**Consultation Response from KC,  
Lead Local Flood Authority**

**2023/93539 Land adj, Ledgard Bridge Mill, Back Station Road, Mirfield, WF14 8NZ**

**Date Responded: 7<sup>th</sup> August 2024  
Responding Officer: Paul Farndale  
Responding Ref:**

Car Park Plan (part) 1: 200

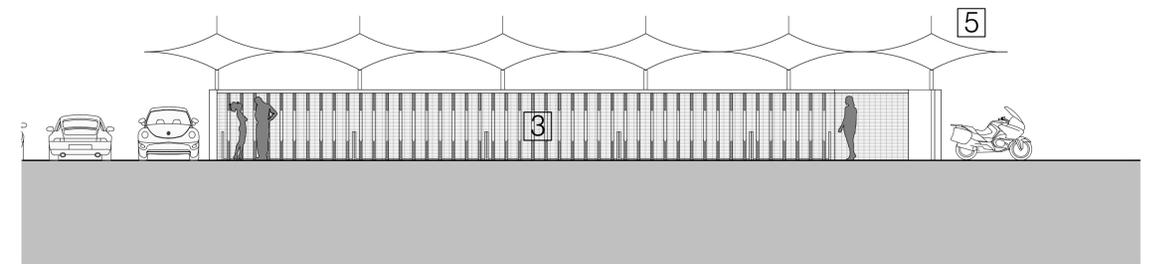
Having said that parking areas are located in flood zone 3 and we cannot see any assessment regarding flood risk associated with this aspect of the development. It is not recommended that a flooding in this area is above 300mm, should the sequential test be passed, and sequential approach relaxed for this site.
